WEST SUSSEX COUNTY COUNCIL CONSULTATION

TO:	Arun District Council FAO: Michael Eastham
FROM:	WSCC - Highways Authority
DATE:	8 March 2021
LOCATION:	Land South of Water Lane Angmering
SUBJECT:	A/24/21/PL Erection of a temporary sales cabin with 4 parking spaces and associated landscaping. CIL Zone 1 - This application is zero rated as temporary building.
DATE OF SITE VISIT:	n/a
RECOMMENDATION:	Advice
S106 CONTRIBUTION TOTAL:	n/a

Project  
**Land at Water Lane,  
Angmering, West Sussex.**  
Drawing Title  
**Sales Area Layout**

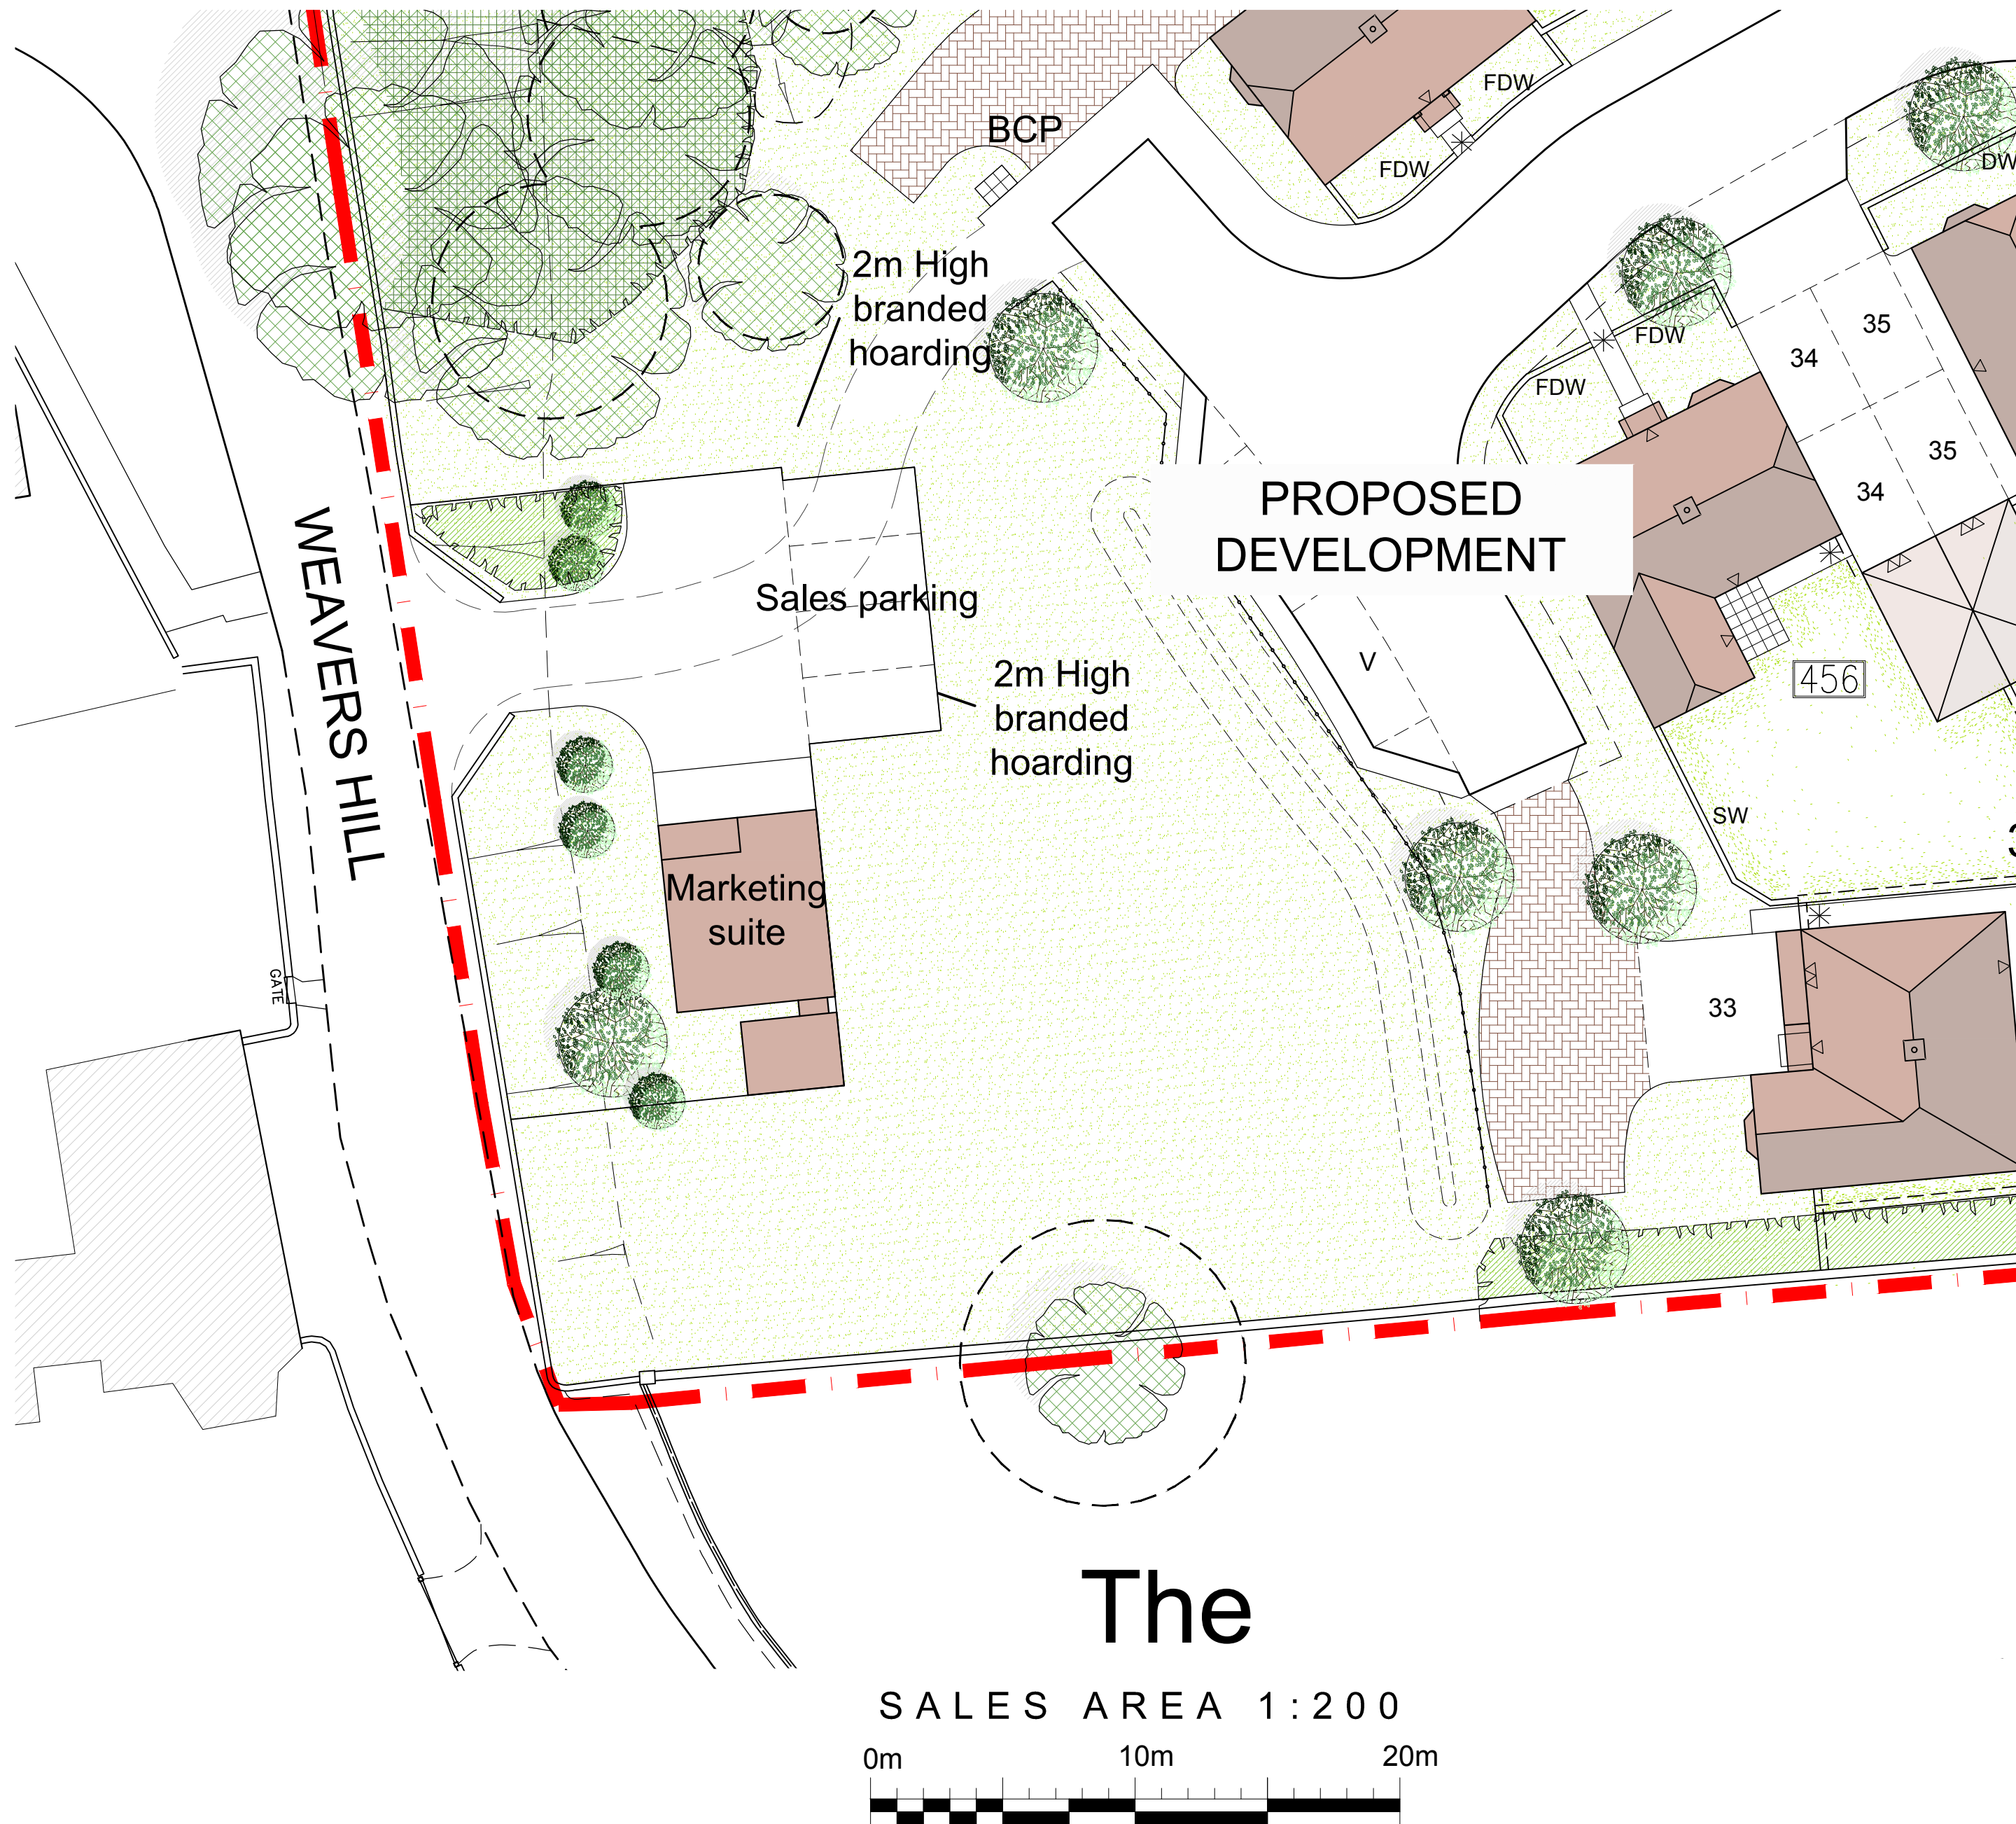
It's recognised that the proposed use is to be accessed from Weavers Hill via an access permitted through A/99/17. The access was permitted through the 2017 application for the purposes of providing pedestrian, cyclist, and as an emergency access. Details of the access arrangement, covered by condition 11 on A/99/17, have been approved through A/201/20. For the purposes of the current application, the only aspect that would sought to be clarified is visibility for emerging vehicles. Whilst this is acknowledged as being a vehicular access, the anticipated level of vehicular use from the permitted scheme would be minimal. As such, confirmation would be sought that adequate visibility can be achieved onto Weavers Hill.

In summary, there are no in principle issues subject to adequate visibility being demonstrated as achievable.
